# Conservation Area Advisory Committee

| Ref                                                                                                                                                                                                        | Description                                                                                                                                                                                         | Address                                                | Design award |
|------------------------------------------------------------------------------------------------------------------------------------------------------------------------------------------------------------|-----------------------------------------------------------------------------------------------------------------------------------------------------------------------------------------------------|--------------------------------------------------------|--------------|
| <u>BN/24/17/PL</u>                                                                                                                                                                                         |

TITLE
PROPOSED GROUND FLOOR PLAN &
ELEVATIONS @ 'LITTLE BARTON',
CHURCH LANE, BARNHAM, W. SUSSEX.

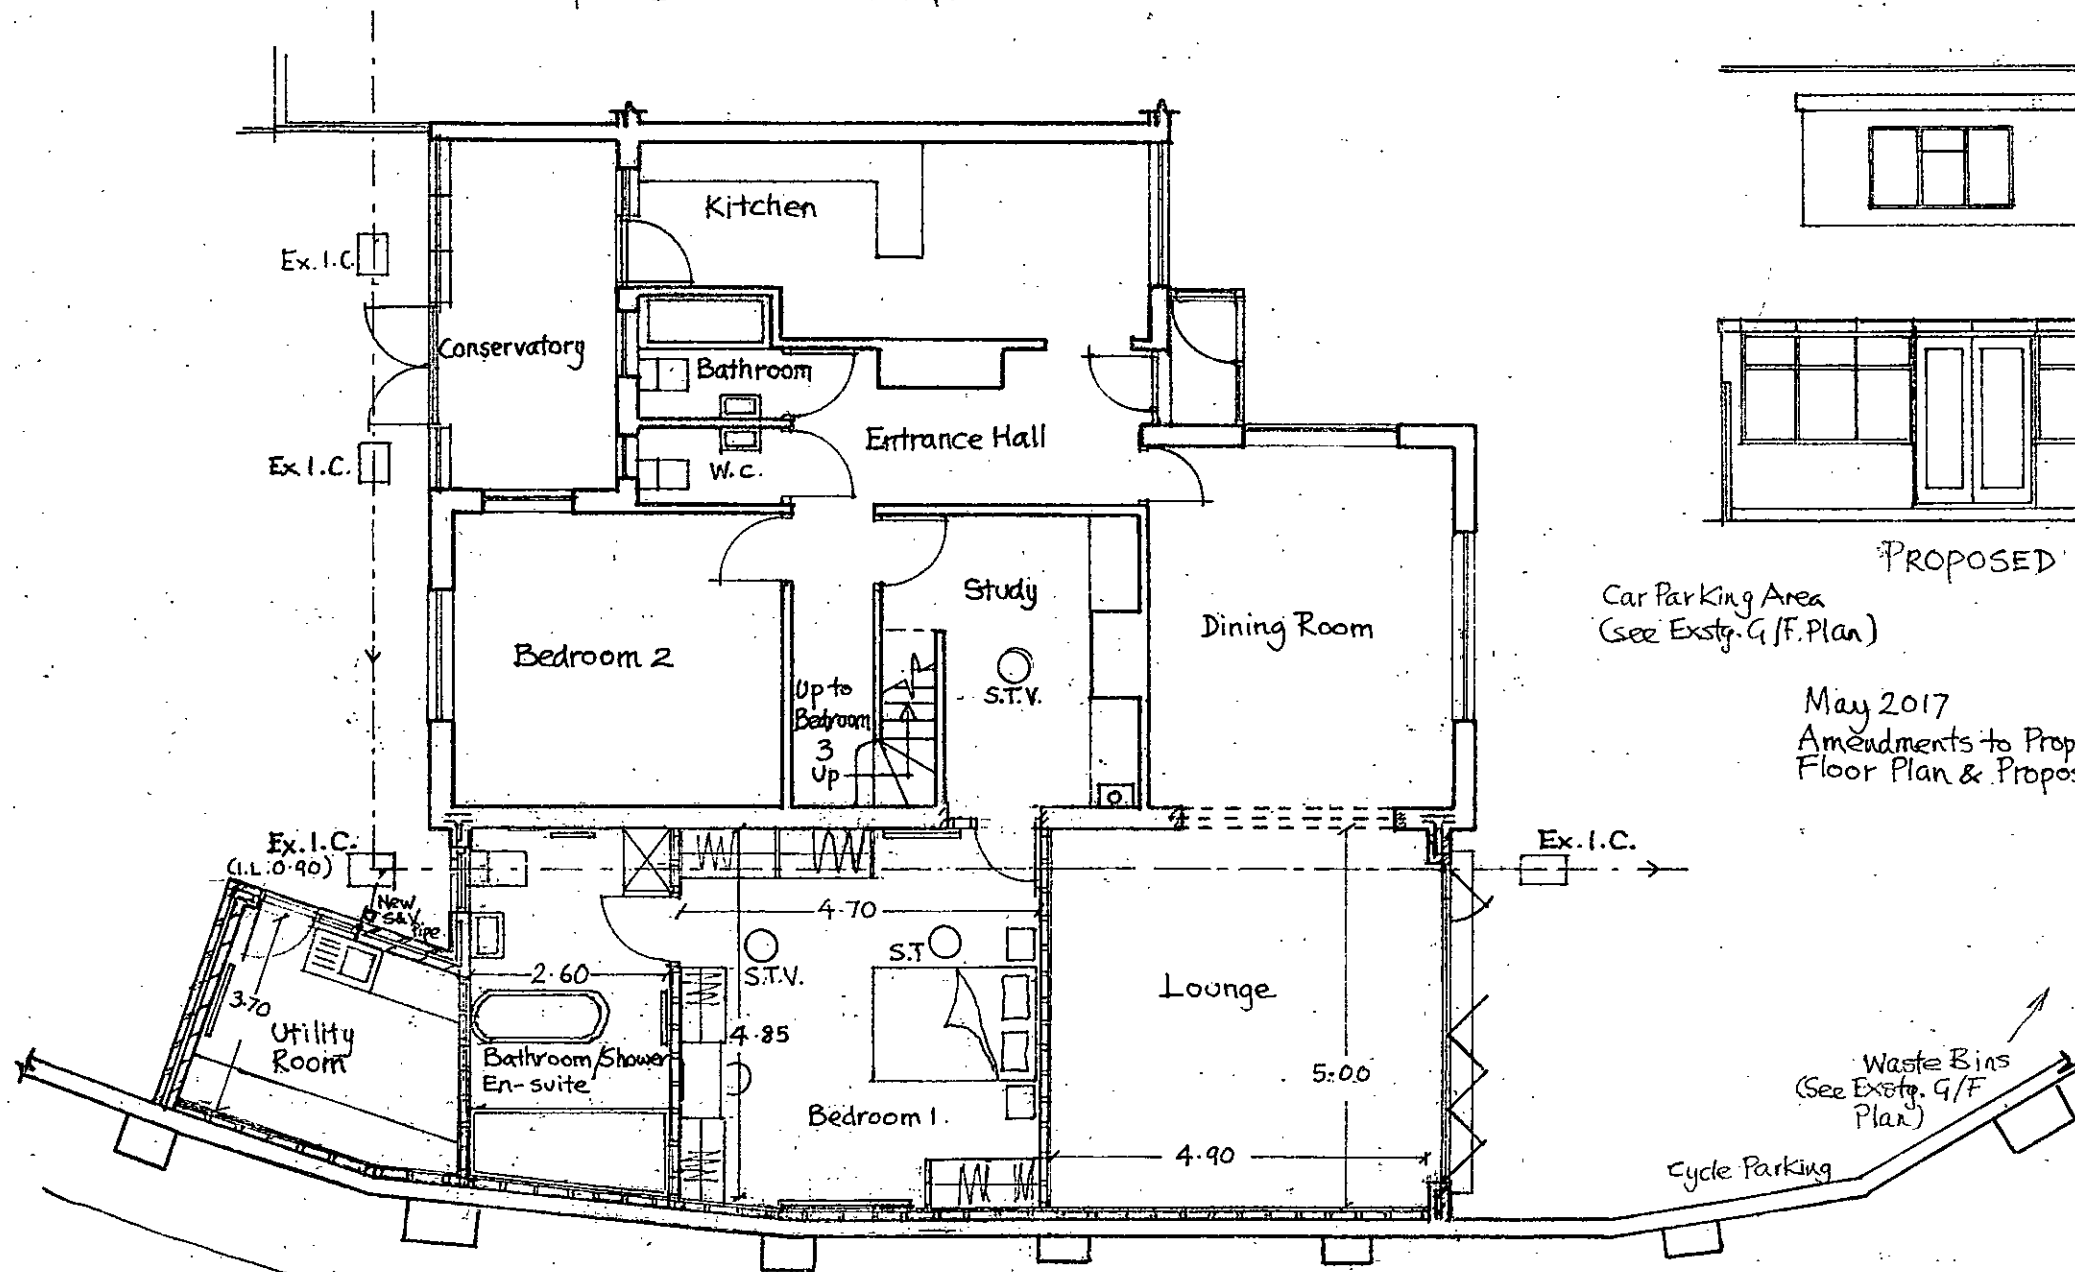
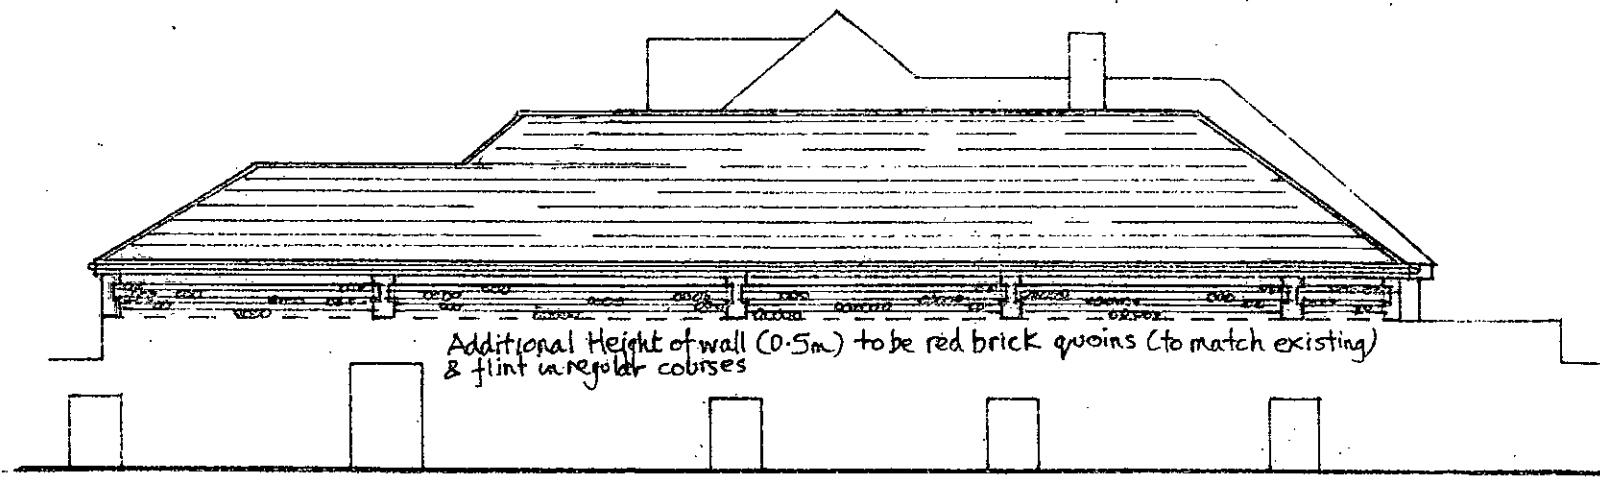
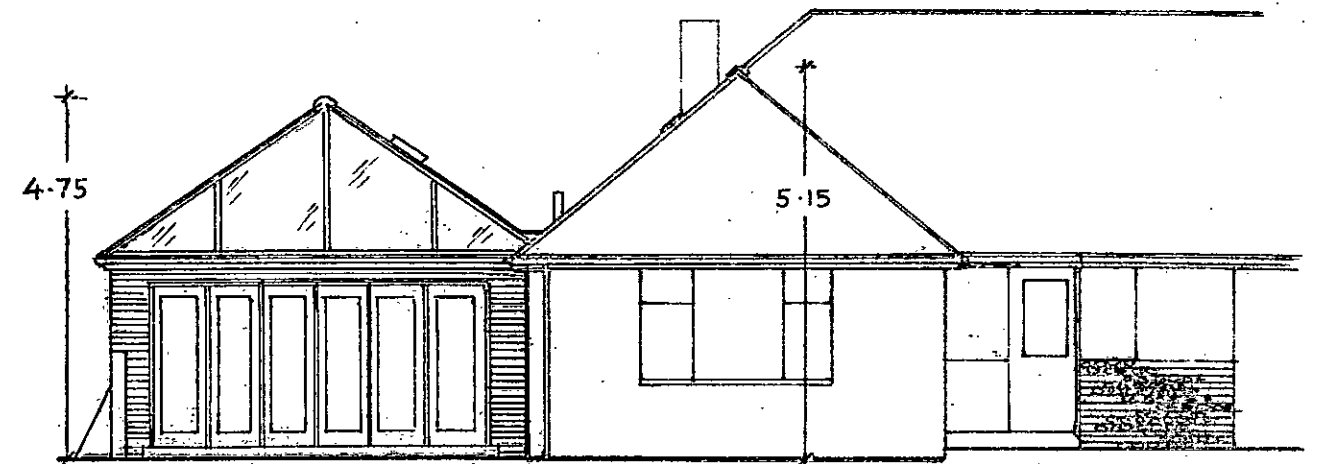
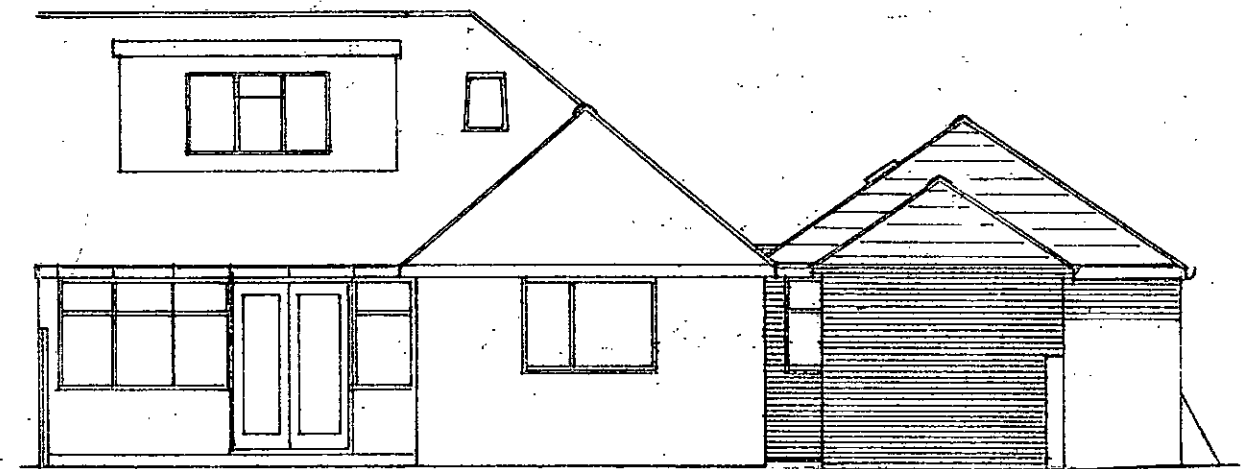
| Ref                                                                                                                                                                                                        | Description                                                                                                                                                                                         | Address                                                | Design award |
|------------------------------------------------------------------------------------------------------------------------------------------------------------------------------------------------------------|-----------------------------------------------------------------------------------------------------------------------------------------------------------------------------------------------------|--------------------------------------------------------|--------------|
| <p>Comments: <i>OBJECTION</i></p> <p>Suggested Conditions: <i>NEW BUILDING TO BE SUPPORTED BY A ROW WALL WITHIN THE BOUNDARY WALL, IN ORDER NOT TO AFFECT THE STABILITY OF THE EXISTING PLINT WALL</i></p> |                                                                                                                                                                                                     |                                                        |              |
